DECISION DELEGATED TO HEAD OF PLANNING

Application No: H16-0209-25 **Applicant:** Castle Events Ltd
Proposal: Removal of tiered benching viewing gallery in the old courtroom
Location: The Sessions House Sheep Market Spalding
Terminal Date: 2nd September 2025

PROJECT TITLE Proposed Removal of Tiered Viewing Gallery	CLIENT Castle Events Ltd, The Sessions House, Sheep Market, Spalding	CHK BY ---	DRAWN BY CLA
DRAWING STAGE Planning	SCALE 1:50 @ A1	STAGE PLN	REV D
SHEET TITLE Removal Plan	PROJECT NUMBER PE11-4138	SHT 002

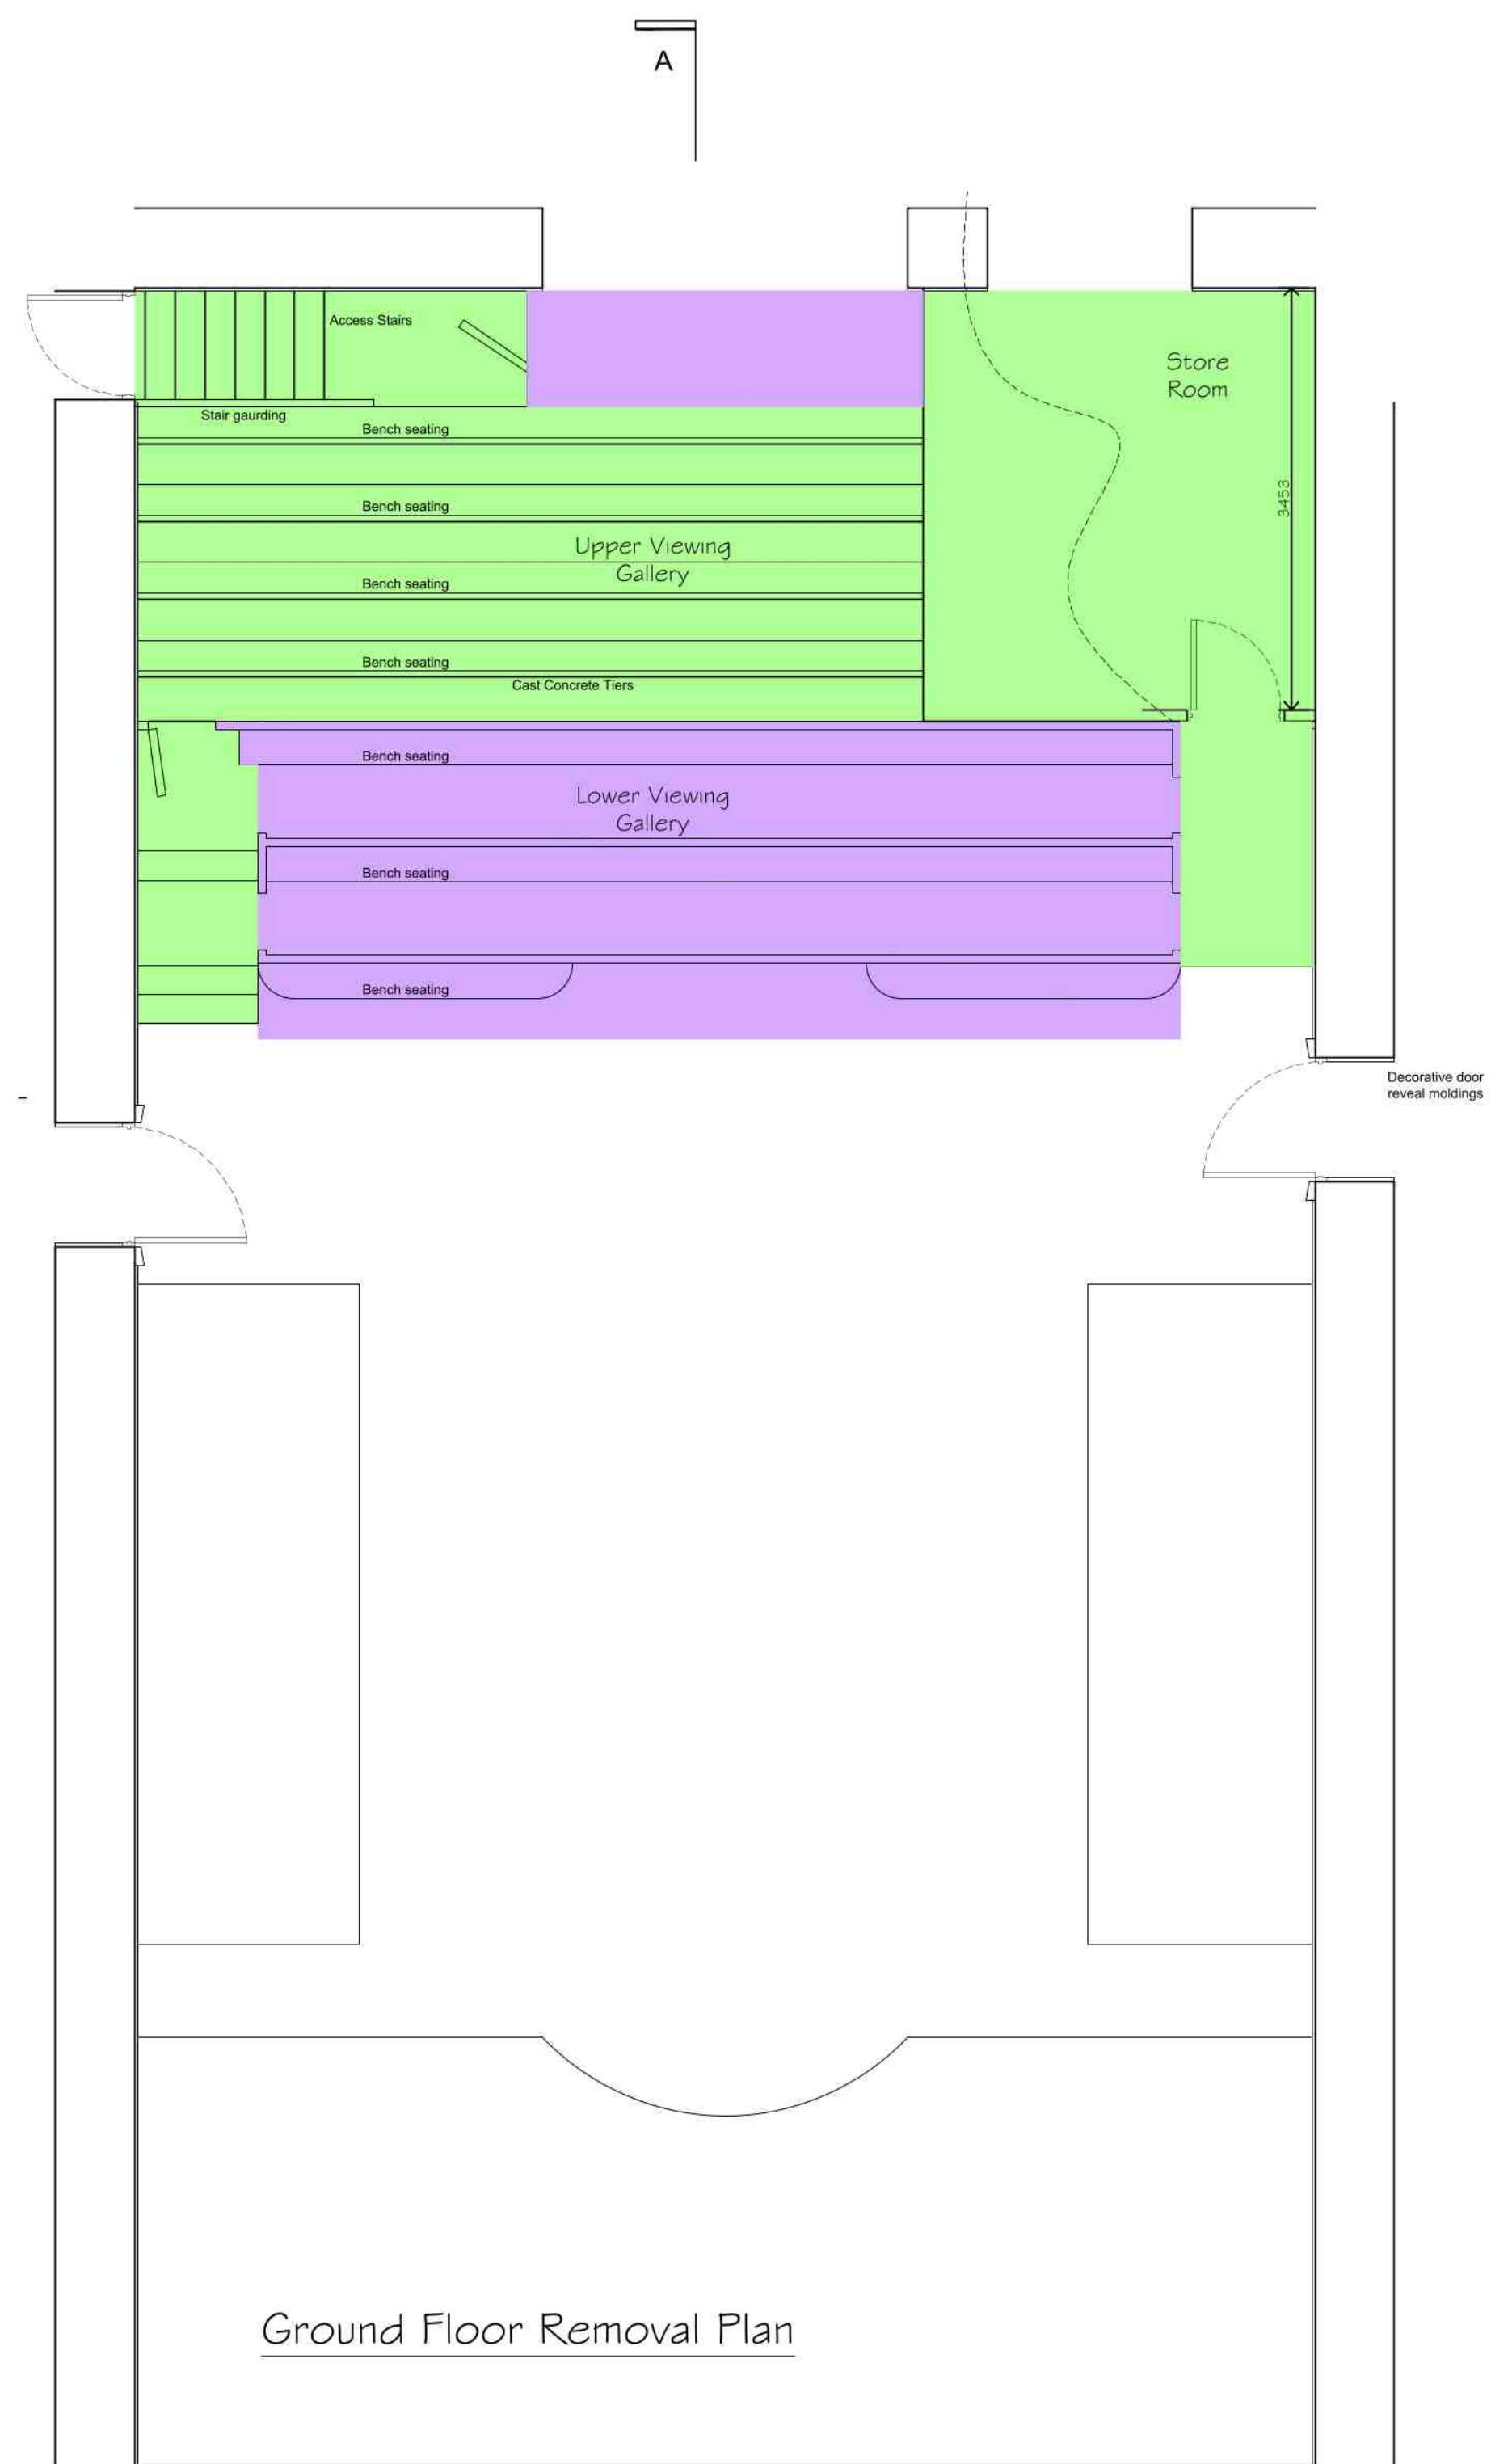
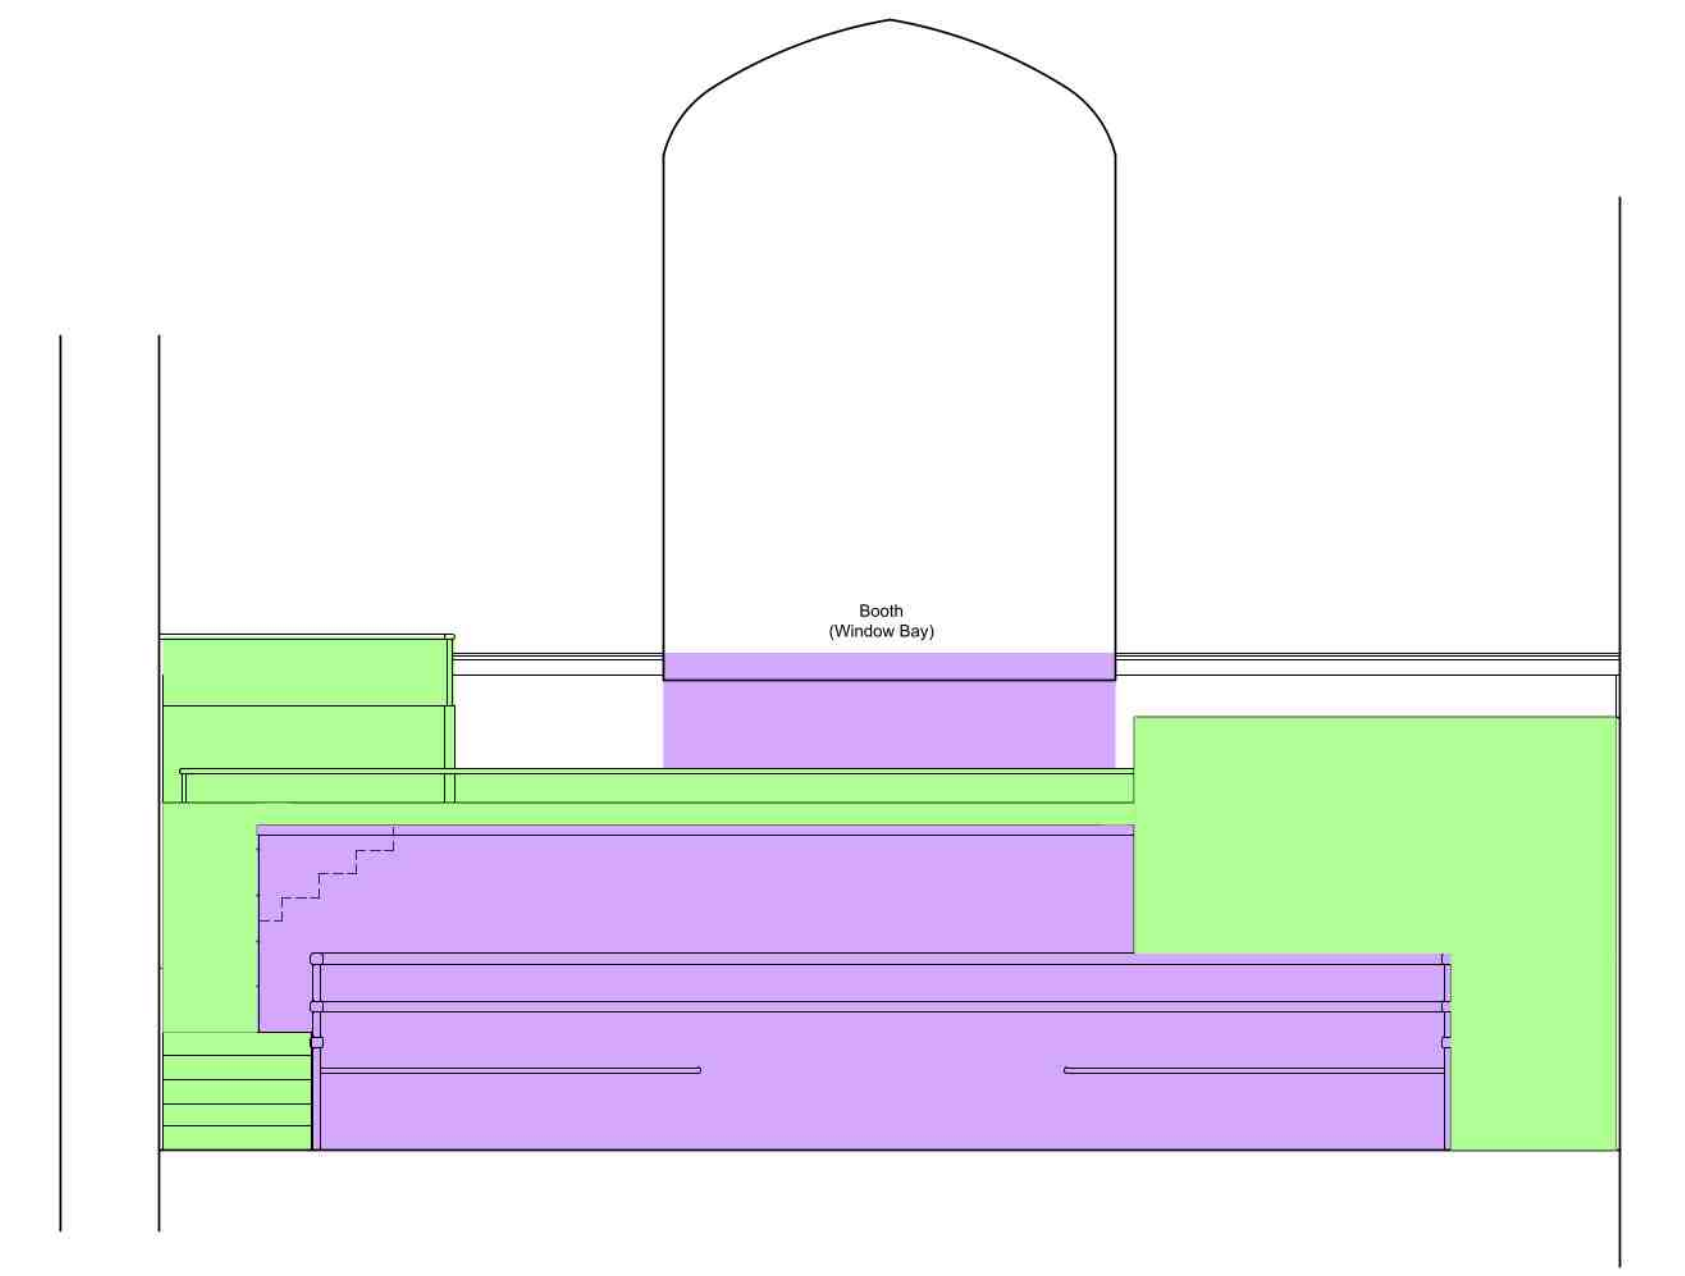
Initially, Historic England objected to the proposed removal of the benching. However, upon receipt of an amended scheme that sought to minimise the removal of original material, Historic England removed their objection, leaving the assessment of the case to the LPA's Conservation Specialist.

Initially, The Victorian Society objected to the proposed removal of the benching. However, upon receipt of an amended scheme that sought to minimise the removal of original material, they removed their objection. Nevertheless, the society did request that further information be provided to ascertain the means by which the retained but unfixed benching should be stored. The LPA determined this could be satisfactorily addressed by means of a condition requiring the storage of the benching on site.

As part of the the JCAS consultation, HB&P were consulted. Whilst the HB&P did not object, they raised concerns with the appearance of the courtroom once the 'store room' were to be removed as it would create an asymmetrical appearance by introducing the store room window into the wider courtroom. The HB&P recommended an options appraisal and an updated HIA to be submitted.

With the above in mind, the Local Planning Authority considers the proposal to represent a form of 'less than substantial harm'. It is categorised as this because although the proposal does seek the removal of a significant amount of historic (although not necessarily original - explored later) fitted furniture, linked to the historic use of the site, the applicant has - by means of amendment to the original scheme - mitigated the scale of the proposal via the retention of the lower, non-tiered section to the frontage that shall be repurposed on site. Moreover, visual inspection of the site would suggest that the furniture is either non-original or at the very least has been substantially modified and reconfigured throughout its history. This is most evident in the fact that the 'store room' (interview room) is clearly non-original, of a mid-late C20th construction and clearly having required major alteration and reconfiguration of the bench seating, which at one point would have occupied the entirety of the space of the rear room including the area now occupied by the interview room. Furthermore, the rear tiered seating is situated on concrete tiered pads, which as HB&P state in their response to the application is highly uncharacteristic. The seating upon these pads is also non-ornamental or ornate, unlike all other seating in the courtroom, and is characteristically mismatched with the remainder on site. This is to the extent that it appears likely that when the interview room was constructed, the current arrangement was installed in replacement of original tiered, timber framed benches. This is further corroborated by the fact that the bench seating at the Boston Sessions House (built in the same year, to a near identical design, by the same architect) utilises bench seating that is far less unadulterated and does not fully match. However what remains of the ornate seating in the Spalding site, does closely match that which is in the Boston facility, suggesting there is a design dichotomy presented by the rearmost tiered seating, suggesting it may not be of an original design or orientation, when compared to a reasonably comparable site.

character of the site than the remaining ornate seating, or at worst have been entirely replaced at some point in the last century for an inauthentic alternative, that has then itself been significantly harmed by the construction of the interview room. Nonetheless, the tiered nature of the design is characterful in and of itself, and therein lies the identified harm in removing this aspect. Considering that much of the original courtroom furniture has been historically removed such that only the dock and side seating remains, and the aforementioned suspected originality of the seating proposed to be removed, it is not felt that this work is impinging upon an especially highly preserved courtroom interior. It is therefore found that the applicant's justification, in allowing the site to be used for a more versatile and viable range of uses, whilst preserving the most important and characterful aspects of the fitted furniture, is acceptable. This position is supported by the latest comments of both Historic England and the Victorian Society.

The Victorian Society also requested details of the storage of the retained benching. However, it is felt that this could be more reasonably secured by means of a condition requiring the retained benching to be stored on site and in association with the Sessions House.
